Oulton Parish Councils response at deadline 8 to applicants deadline 7 submissions

Technical Note Responding to Norfolk County Council's Request for Trenchless Crossings of the A1067 and B1149

OPTION 1: PASSING PLACES

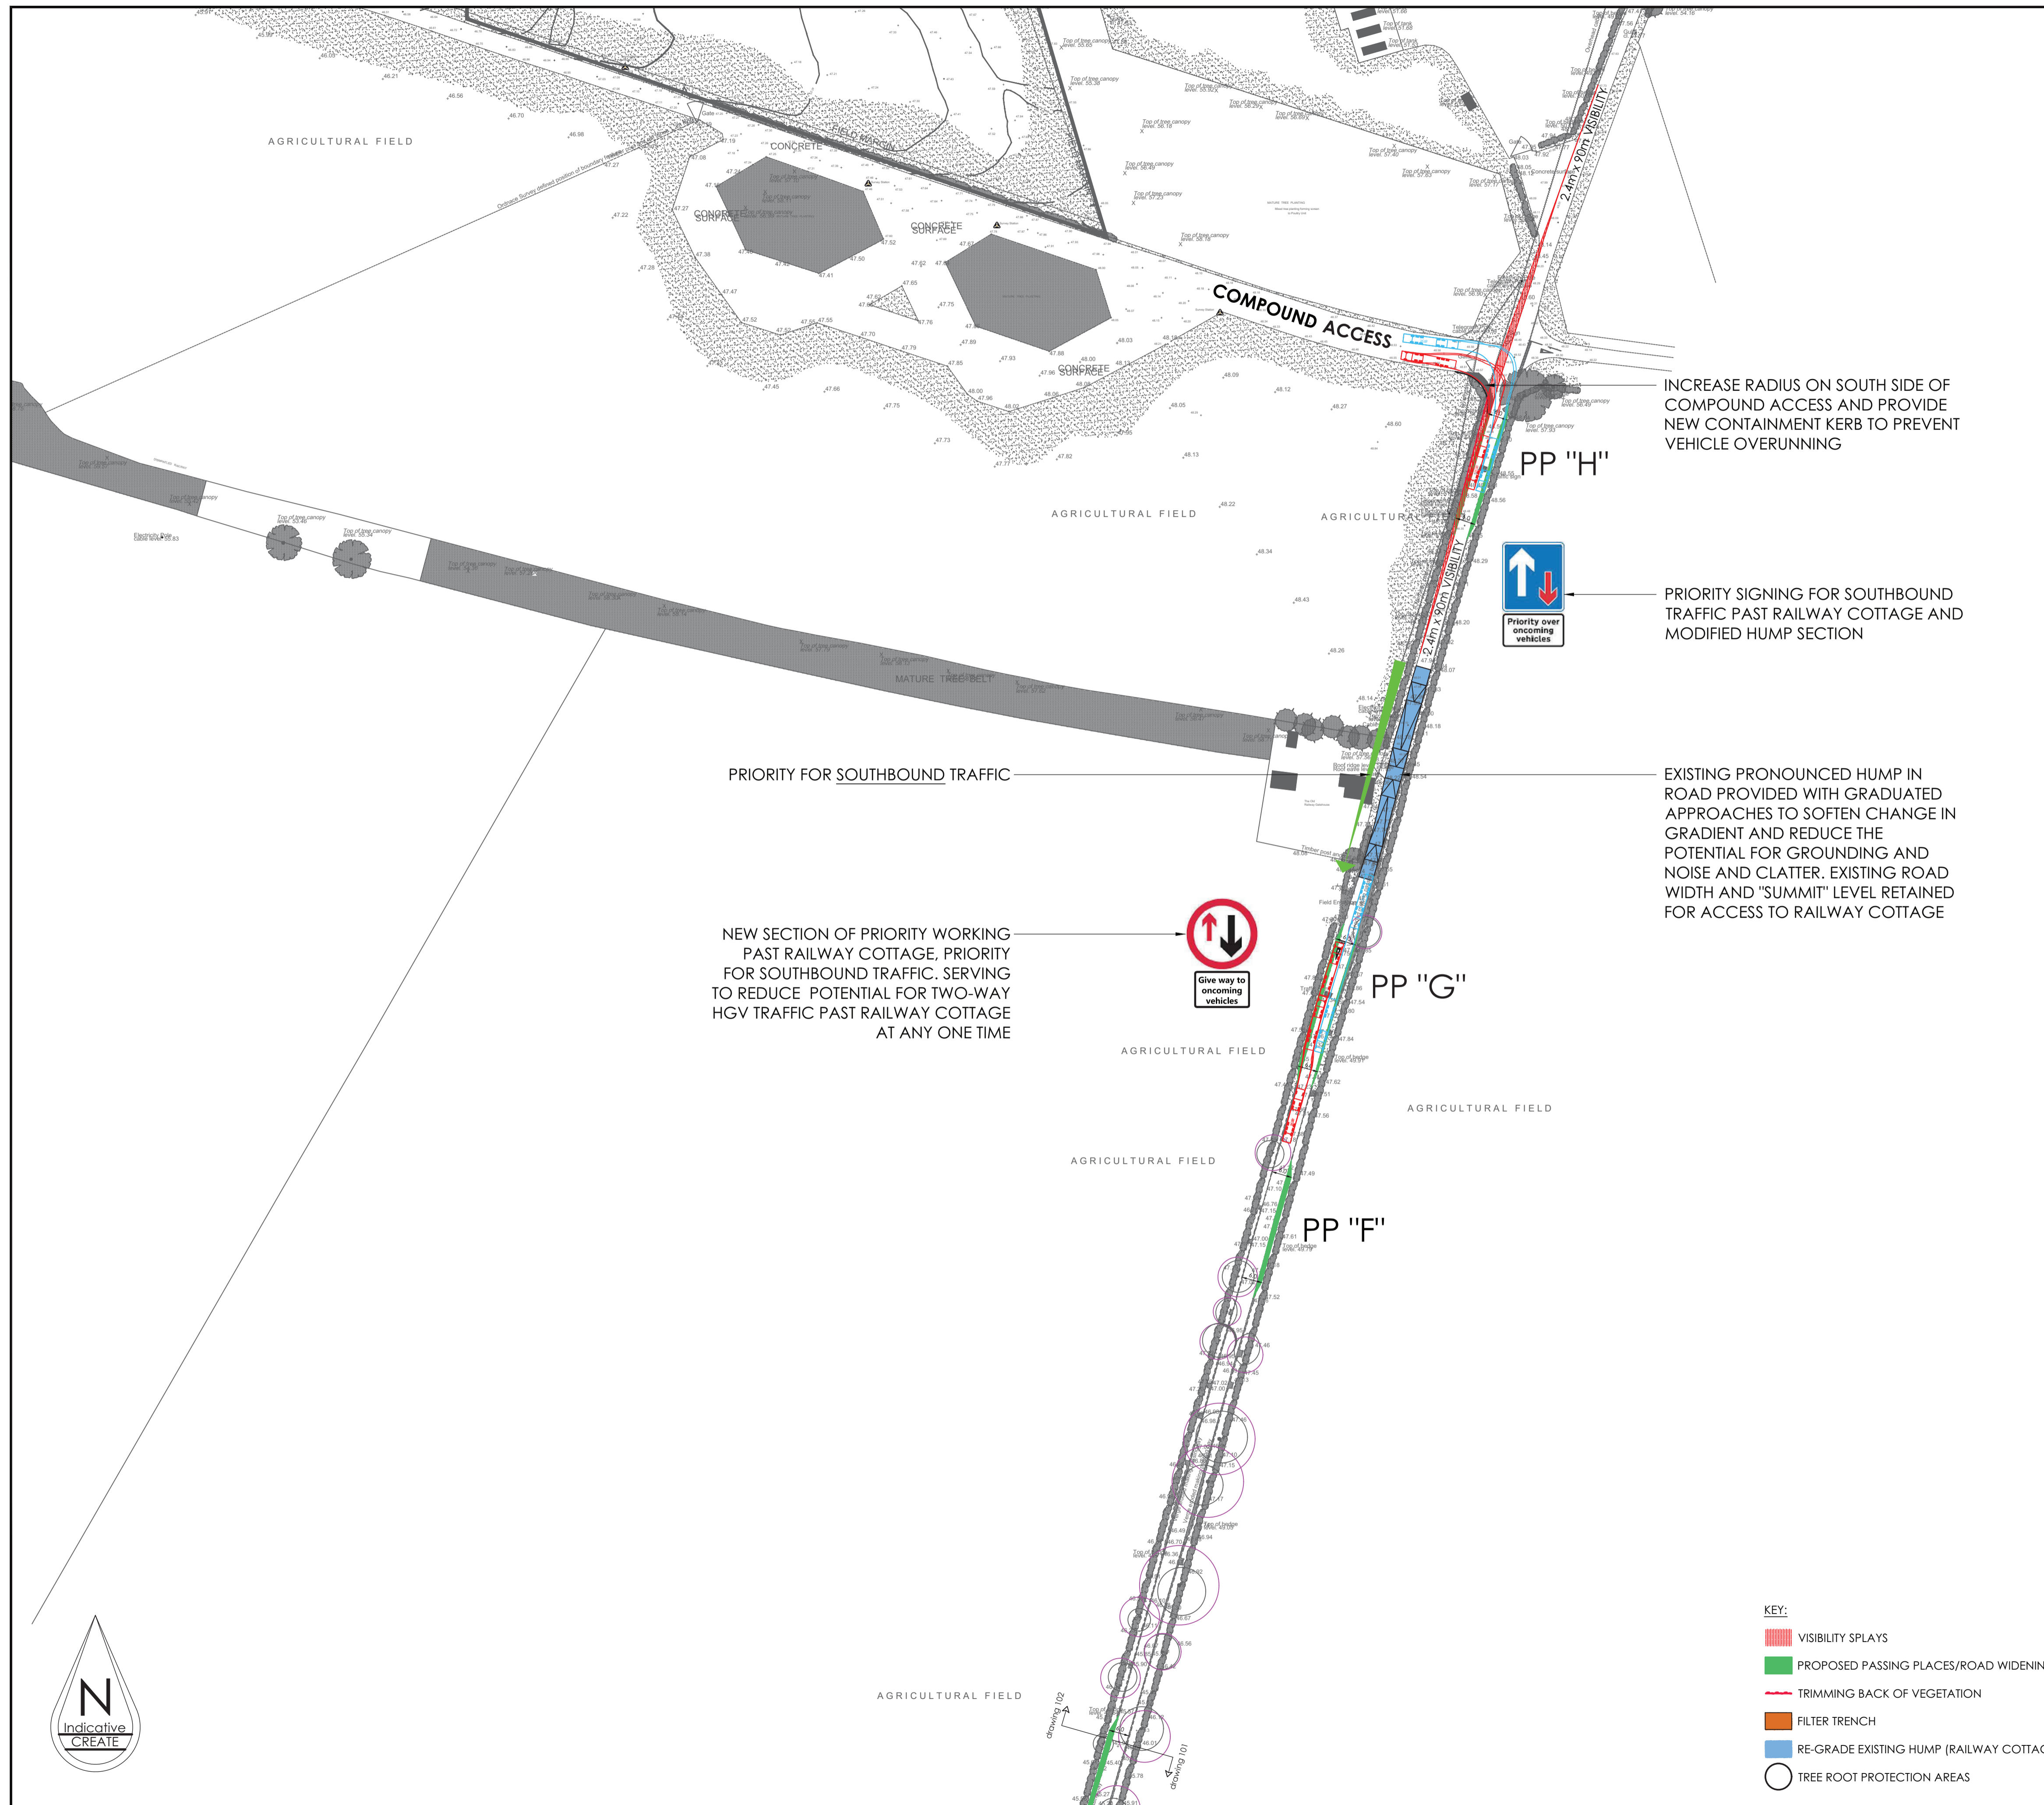
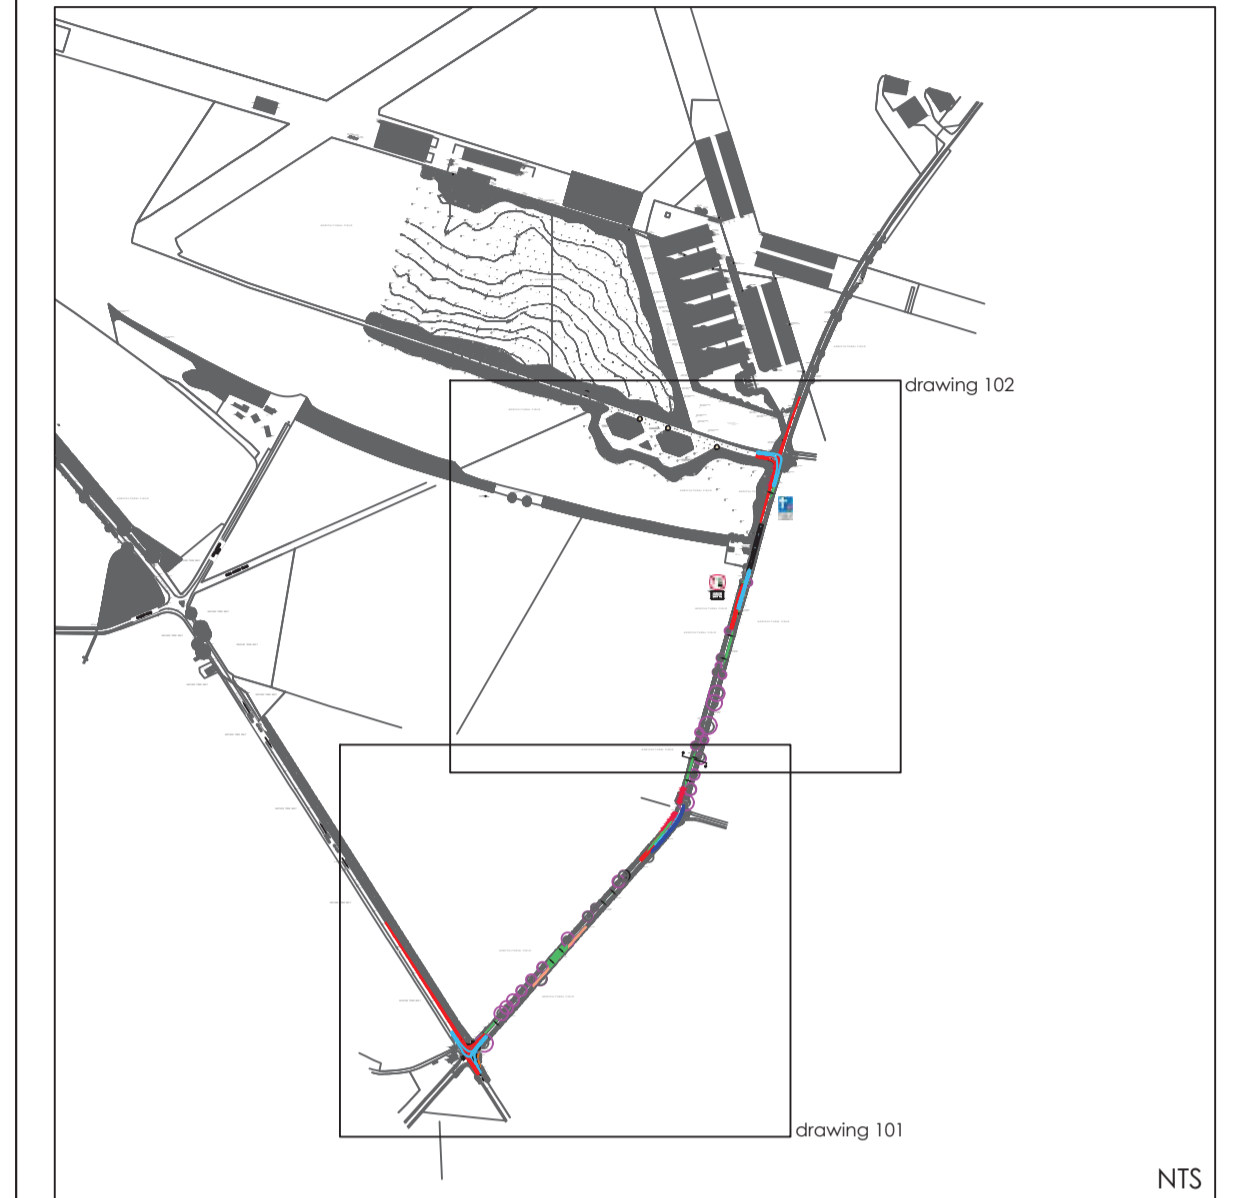
In close proximity to The Gatehouse is the entrance to HOW3 compound and Heydon Rd route to MA7/Cable logistics area. Traffic will have to stop to assess whether they can proceed onto The Street and would then have to stop to give way according to what is proceeding along the priority signed stretch of road at the Gatehouse. This would account for at least 4 scenarios for stopping and starting.

The applicant has gone onto assessing the impact of traffic waiting in the lay-by (Passing place) and stated in the **Noise mitigation Measures** document that: **10% of HGV traffic would be required to wait in the lay-by until the carriageway was passable;**

However on reading the Air Quality Assessment which has also been re-run, OPC note that there was another scenario of **25% of HGV traffic waiting** in the Lay-by (Passing place), this second scenario used in the air quality assessment seems to have been overlooked in the Noise Assessment.

Figure 1 Location of Old Railway Gatehouse

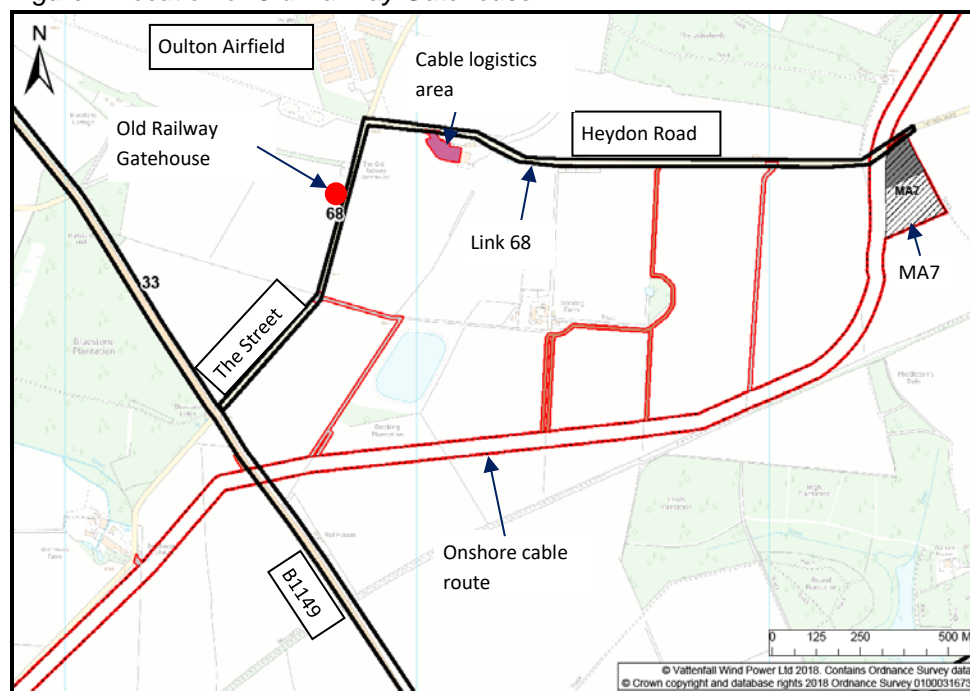
Air Quality – The Old Railway Gatehouse

The applicant has concluded that the Air Quality Assessment will result in a negligible impact. The assessment methodology used, ***as set out in section 26.4.1.2 of Environmental Statement Chapter 26 Air Quality.***

OPC note that their query regarding Intensive farming was investigated and emissions from ammonia were put to one side. However the applicant did acknowledge that ammonia emissions can result in secondary particulate matter and goes on to say

OPC questions whether the levels of PM10 emissions from the intensive turkey farm, plus the addition of assessed cumulative traffic and dust from construction materials would be within the objective of annual PM10 40 µg/m3?
